Response to Planning application from Hertfordshire County Council (T and CP GDP Order 2015)

District ref: 6/2022/0922/FULL
HCC ref: WH/12437/2022
HCC received: 31 May 2022
Area manager: Matthew Armstrong
Case officer: Steven Knight

11 TOLMERS GARDENS CUFFLEY POTTERS BAR EN6 4JE

Conversion and extension to existing single dwelling house to create 4x 1 bed apartments with associated infrastructure

GROUND FLOOR PLAN
 1:100

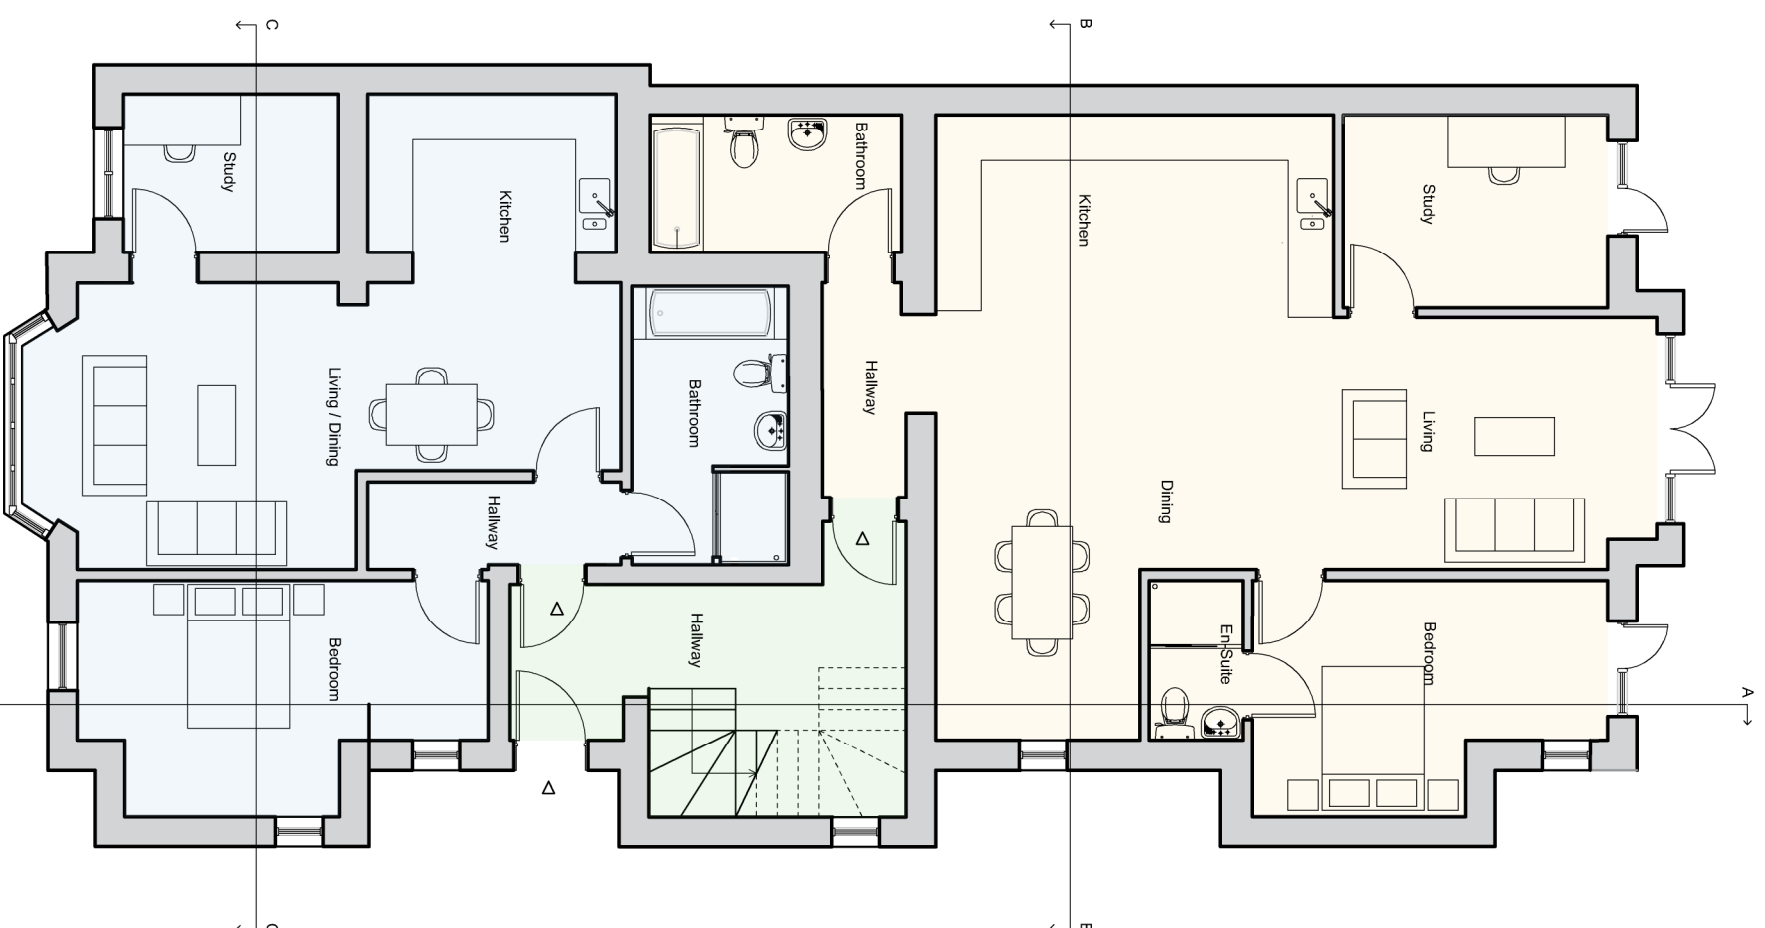
However, based on the proposed parking layout, it appears that all four spaces will be accessed directly from the highway requiring a continuous vehicle crossing approximately 10m in length. This will not comply with HCC's Dropped Kerb Terms and Conditions document which states that the maximum width of a vehicle crossing is 3.6m (four flat kerbs).

The highway authority has no concerns regarding inter-vehicle visibility because an appropriate visibility splay could be accommodated almost entirely within the highway given the width of the footway. However, the applicant should demonstrate that a 0.65mx0.65m pedestrian visibility splay can be accommodated, particularly for space '1' due to its proximity to the neighbouring fence.

The proposed parking spaces are all adequately sized but are obstructed by what appear to be triangular raised planters. This is likely to mean that vehicles will overhang the footway.
